ARVIDSON SUBDIVISION

Administrative Relief Site Plan Map
ARVIDSON SUBDIVISION

MVE PROJECT: 61049
MVE DRAWING: -Site-Plan
DATE: NOVEMBER 07, 2017
SHEET: 1 OF 1

ARVIDSON SUBDIVISION

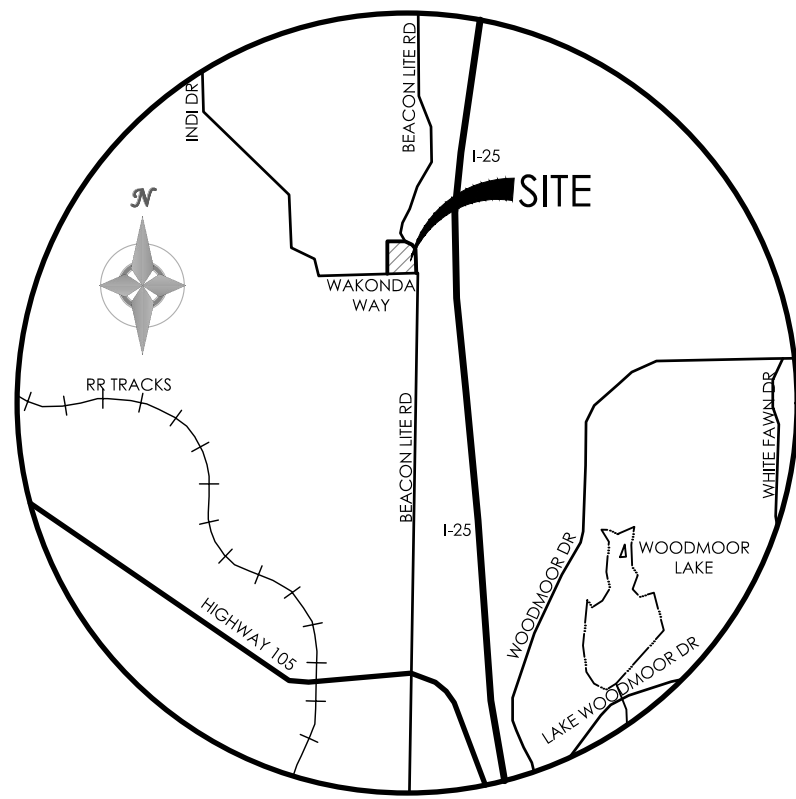
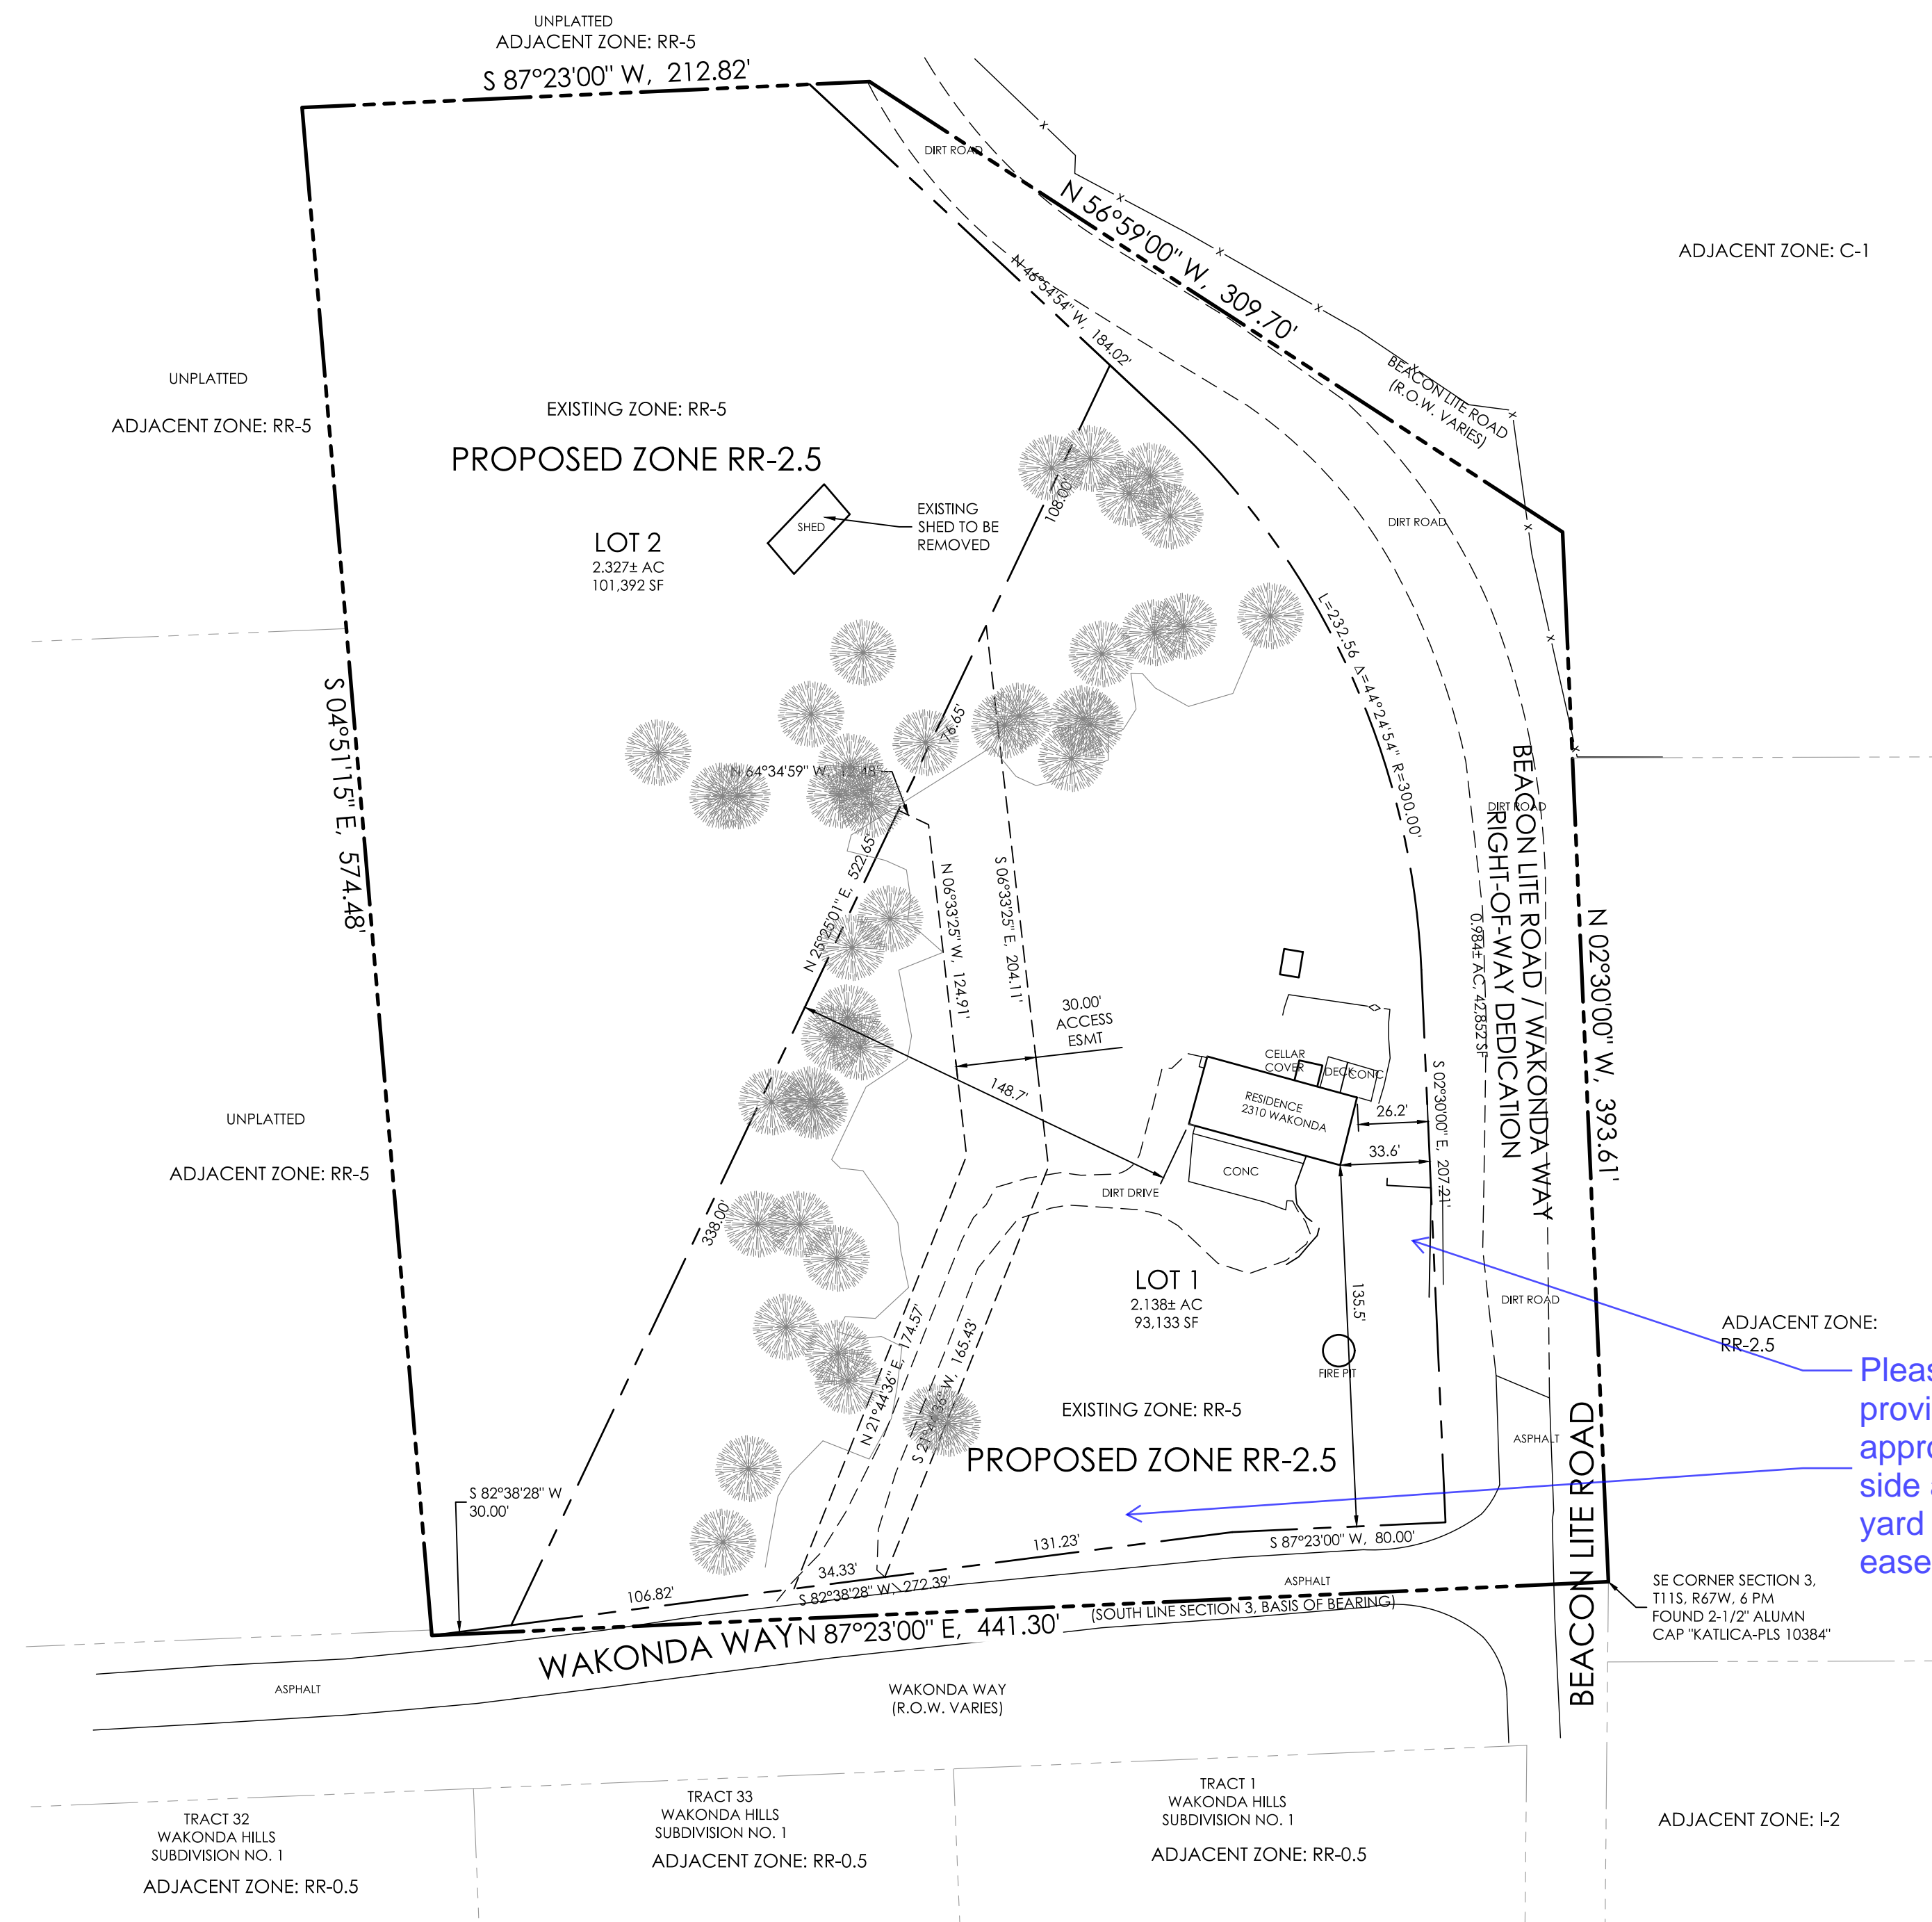
Please call out existing EOA, and provide distances to property line relative to existing centerline of BL road. The current EPC MTCP shows 90' of ROW required for BL road, please show the future ROW centered on the existing road.

Please call out as "Kitlica" monument
